STANSTED AIRPORT AERODROME SAFEGUARDING AUTHORITY PLANNING APPLICATION CONSULTATION RESPONSE – under Circular 1/2003 Safeguarding Aerodromes, Technical Sites and Military Explosives Storage Areas: the Town and Country Planning (Safeguarded Aerodromes, Technical Sites and Military Explosives Storage Areas) Direction 2002				
Planning Authority:	UDC		Application No: UTT/23/2552/FUL	
Development Proposal:	New dwelling and cart lodge/home study			
Location:	Mayrose House Great Canfield Road Takeley			
OS Co-ordinates (Eastings/Northings):	557167/220941			
Our Reference:	STN 262			
No Objection	Crane Advisory Permit Required	Need to engage with MAG Safeguarding	Request Conditions	Objection
X	X		X

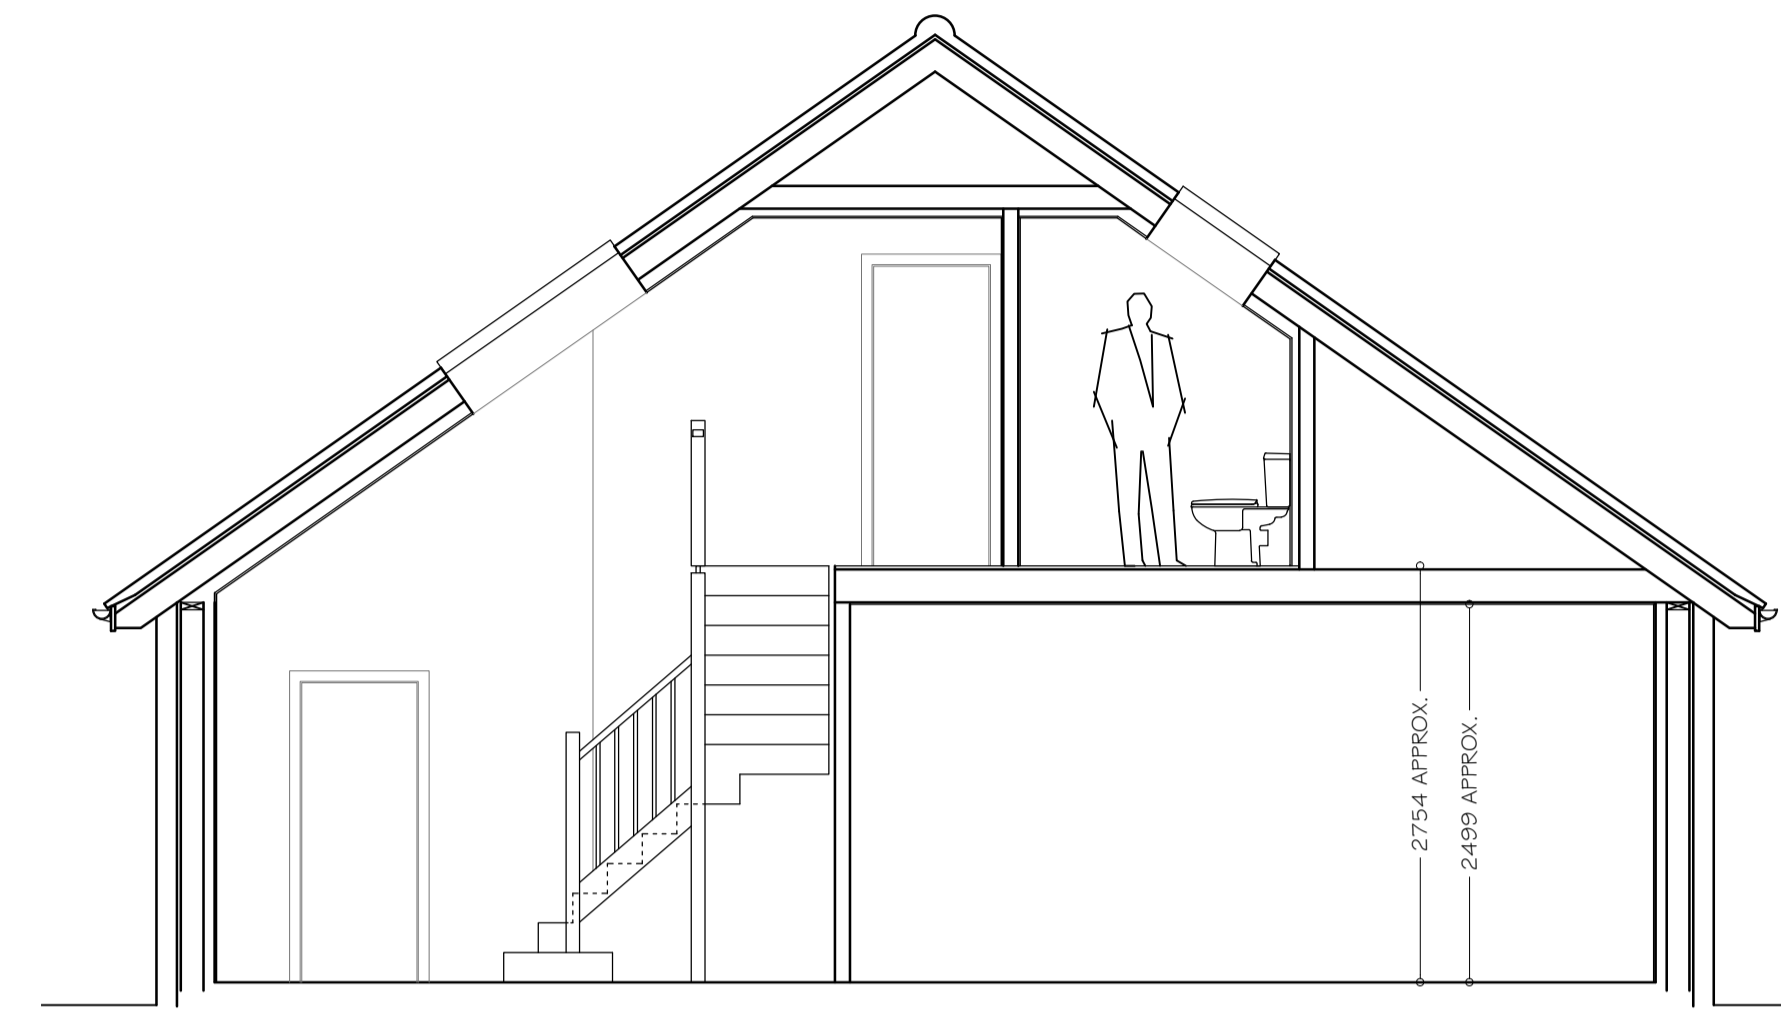
-No lighting directly beneath the roof lights that will emit light upwards – only downward facing ambient lighting to spill from the roof lights upwards – ideally, automatic blinds to be fitted that close at dusk.

Reason: Flight safety - to prevent distraction or confusion to pilots using Stansted Airport.
